**RE: Primrose School of Sandia Heights
Grading and Drainage Plan
Engineer's Stamp Date: 01/25/18
Hydrology File: D19D030**

Based upon the information provided in your submittal received 01/25/2018, the Conceptual Grading and Drainage Plan **is not** approved for Site Plan for Building Permit. The following comments need to be addressed for approval of the above referenced project:

CONCEPTUAL GRADING & DRAINAGE PLAN

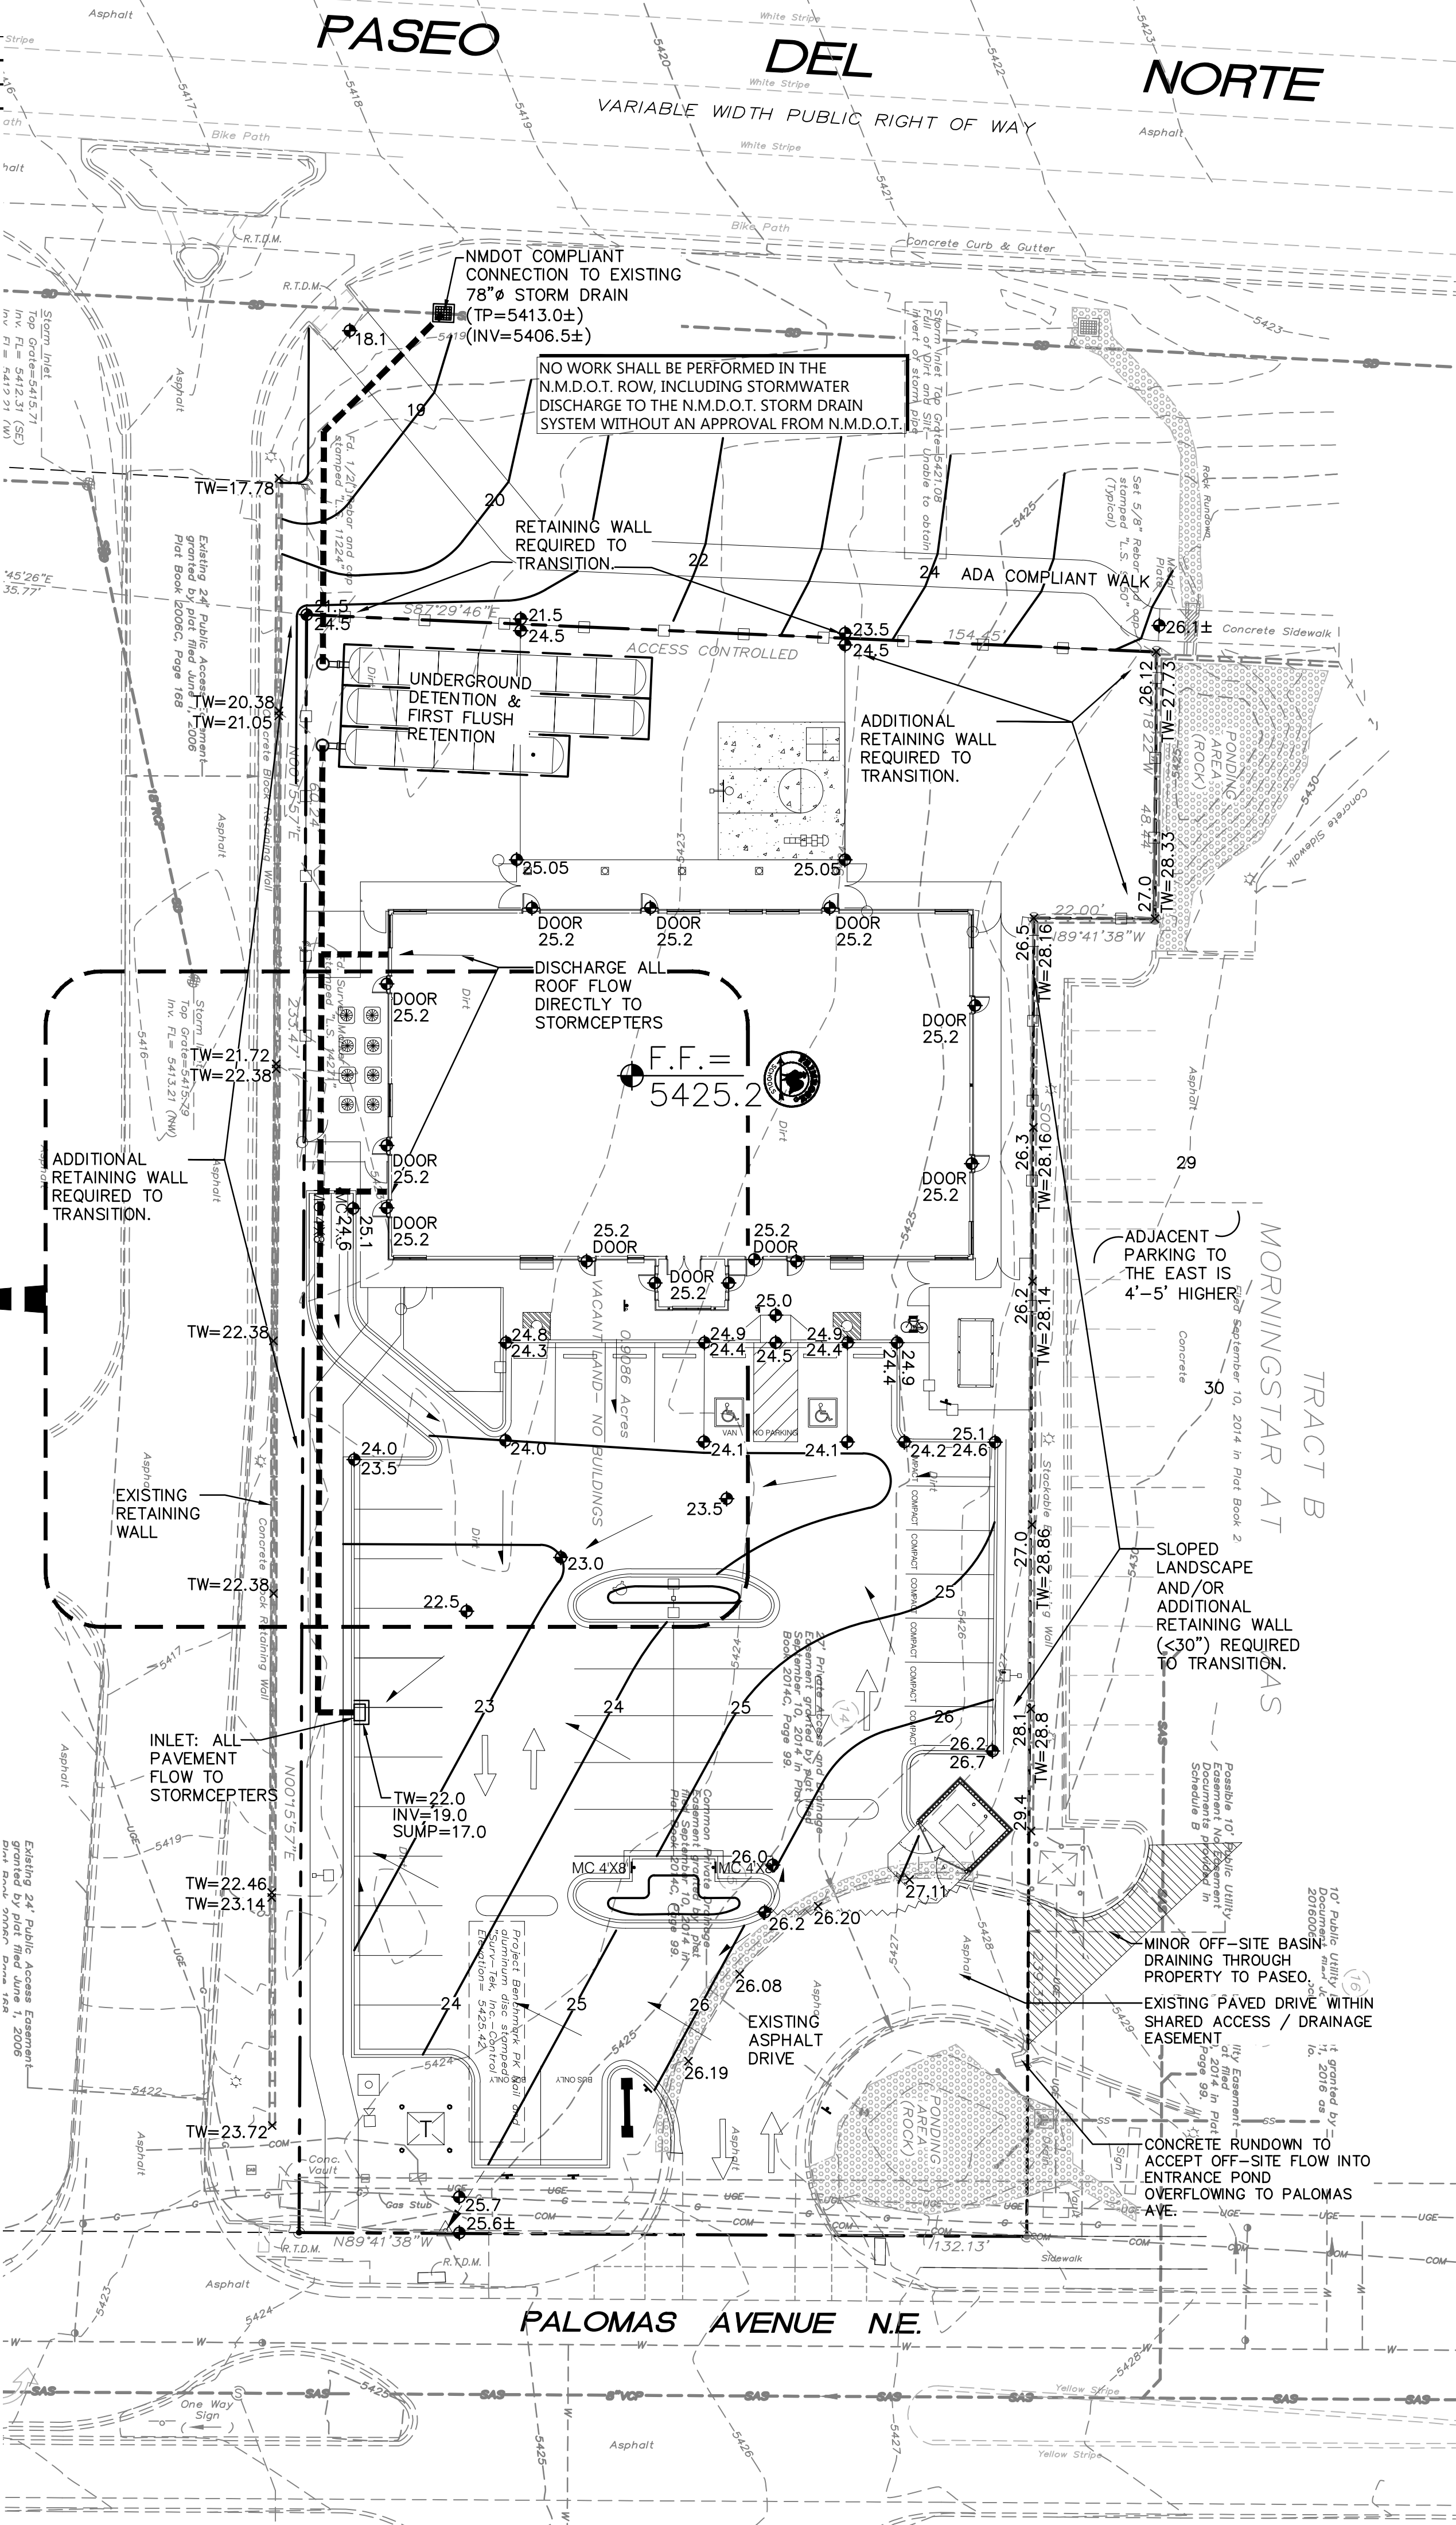
1. Please place the road names on the Conceptual Grading Plan.
2. Please show the limits of the construction. Please make new construction line work darker than the existing line work. The proposed grades, contours, storm inlet, and pipe are perfect. Just make the proposed curb, sidewalk and building between what it is now and the proposed contour thickness.
3. How is the proposed storm sewer connecting to the existing NMDOT storm sewer? It appears that you are missing two manholes on the outfall pipe of the underground detention.
